CITY OF ALBUQUERQUE

Hydrology Section Planning Department
Brennon Williams, Acting Director

February 3, 2020

**Re: Palomas Peak Offices - 8310 Palomas Ave NE
Erosion Sediment Control Plan
Engineer's Stamp Date 1/29/2020 (D19E031)**

TEMPORARY EROSION AND SEDIMENT CONTROL PLAN

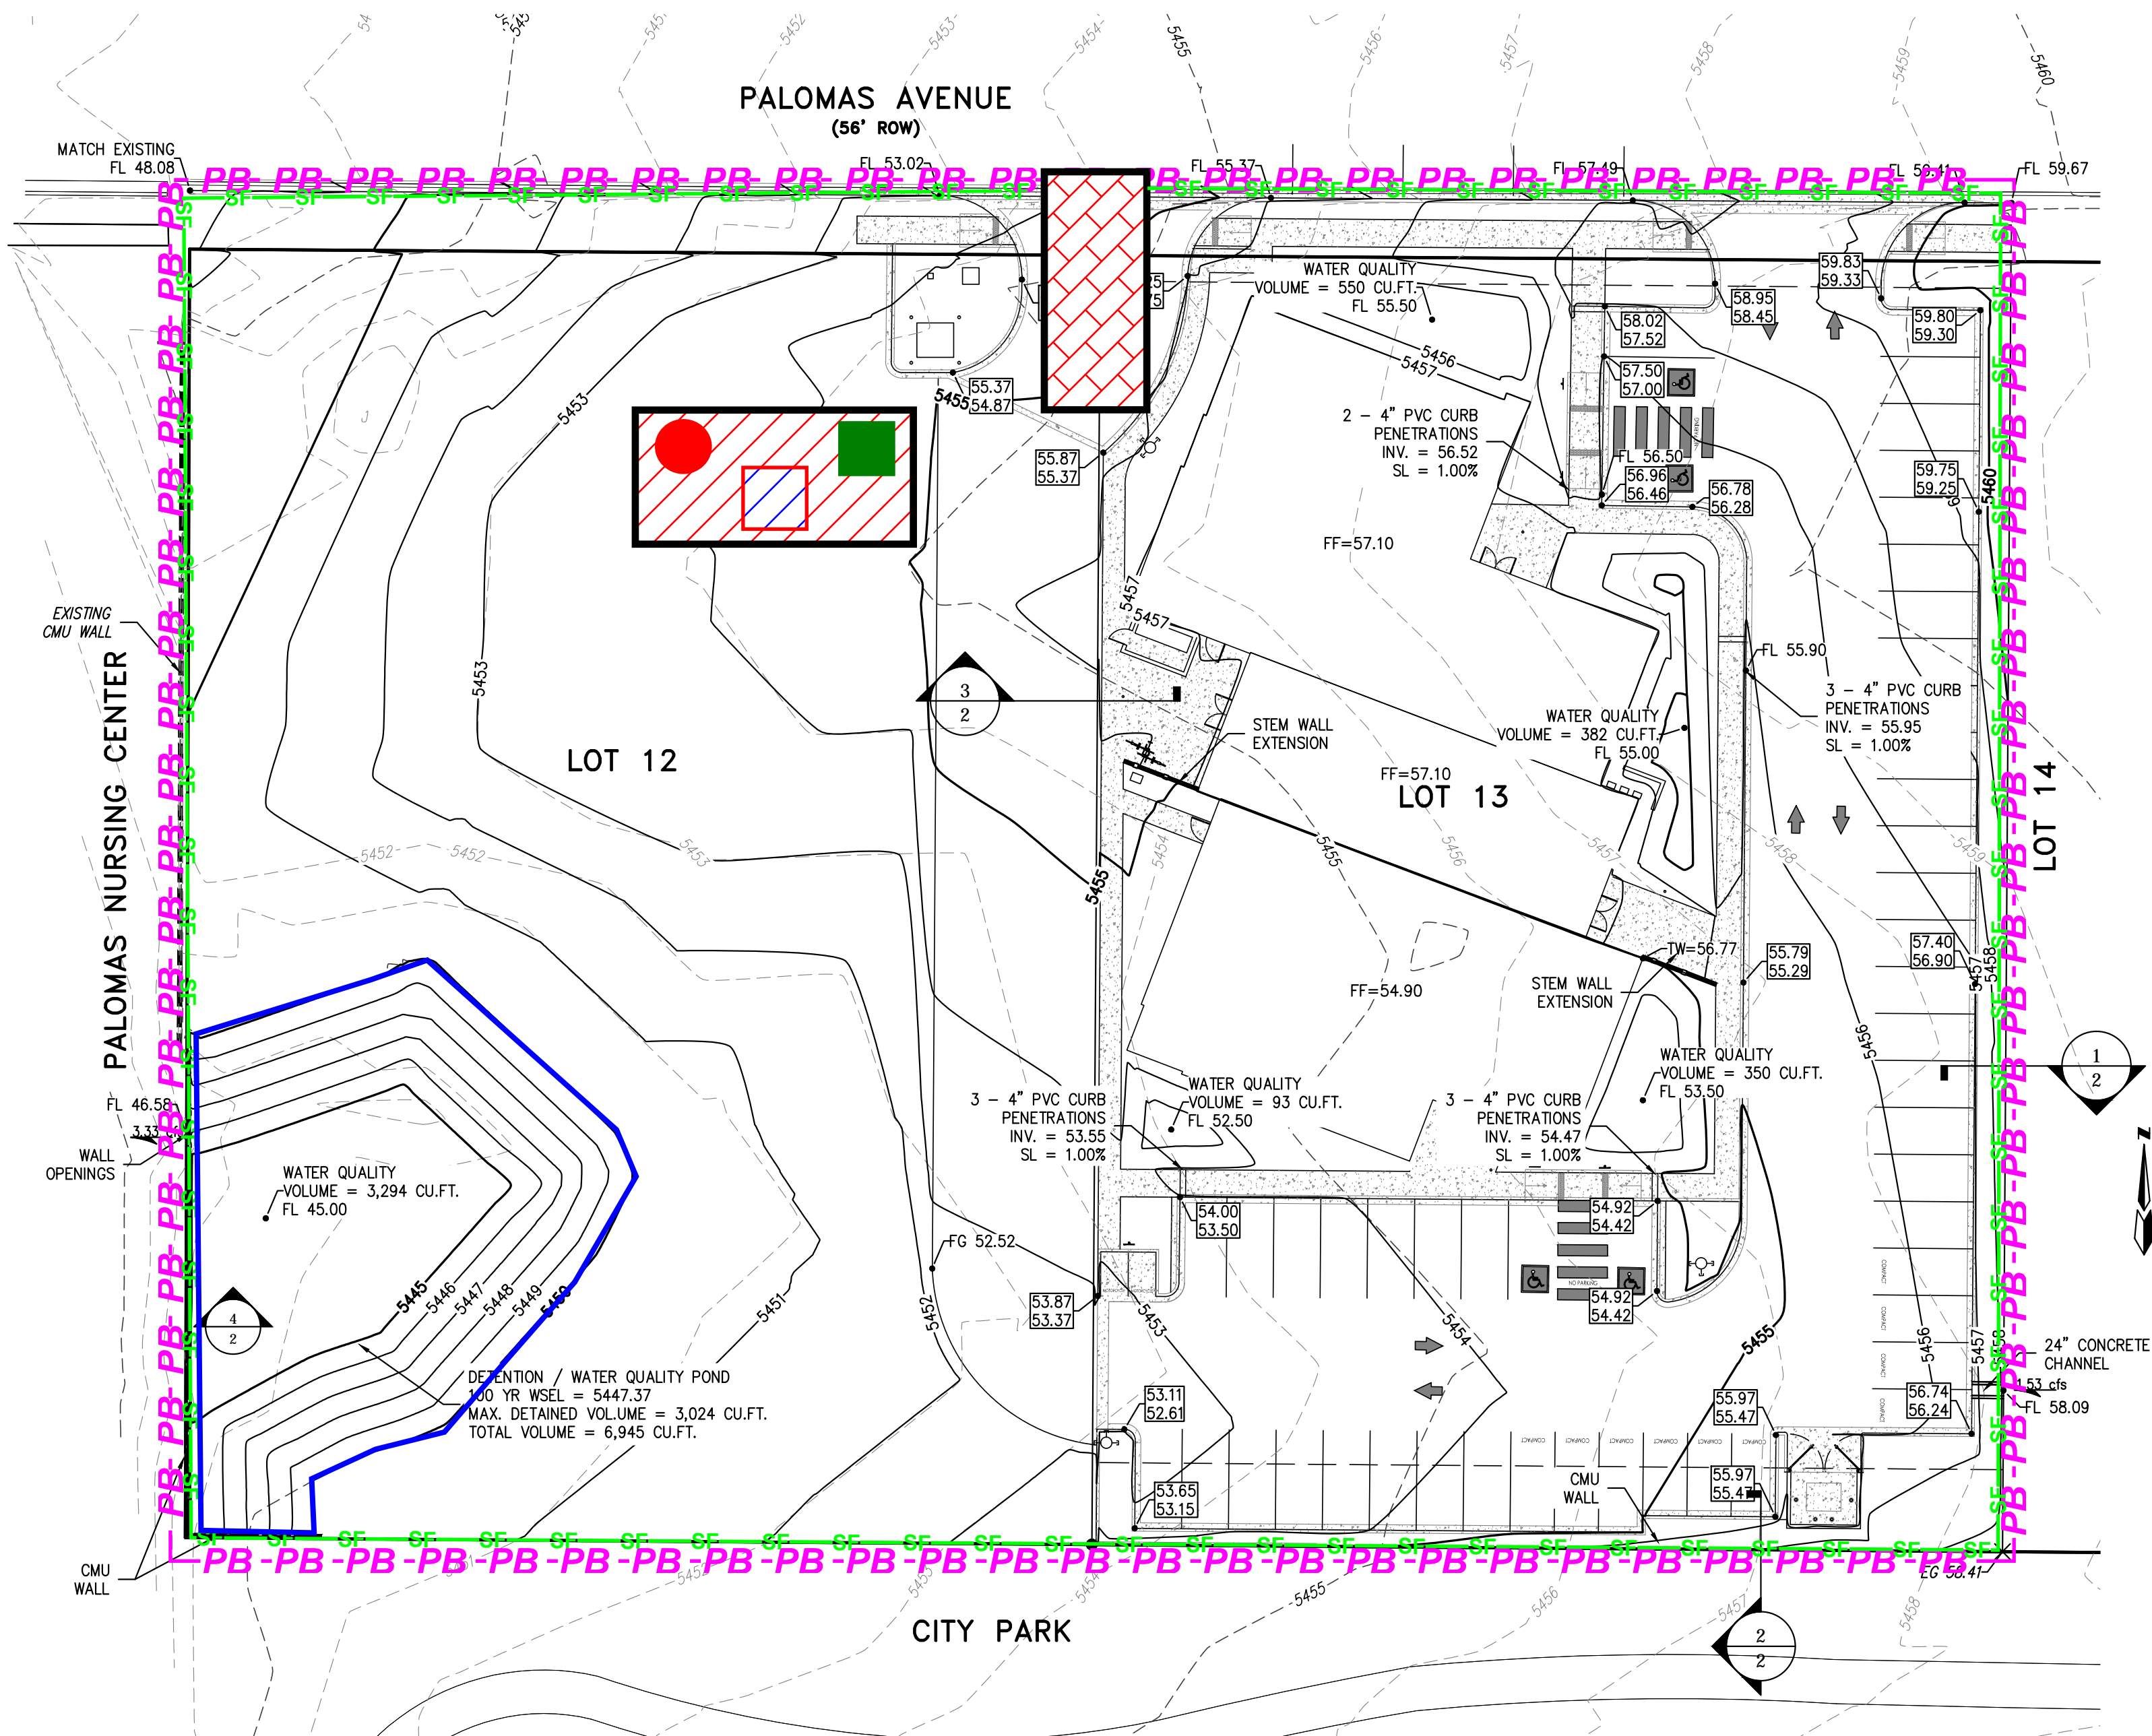
1. The area draining to the southwest corner of the site exceeds the commonly accepted limitation of $\frac{1}{4}$ acre per 100 LF of silt fence. Please change the plan to provide a temporary sediment trap in the location of the permanent pond.
2. Please add the following standard notes to this and all subsequent plans in the City of Albuquerque.
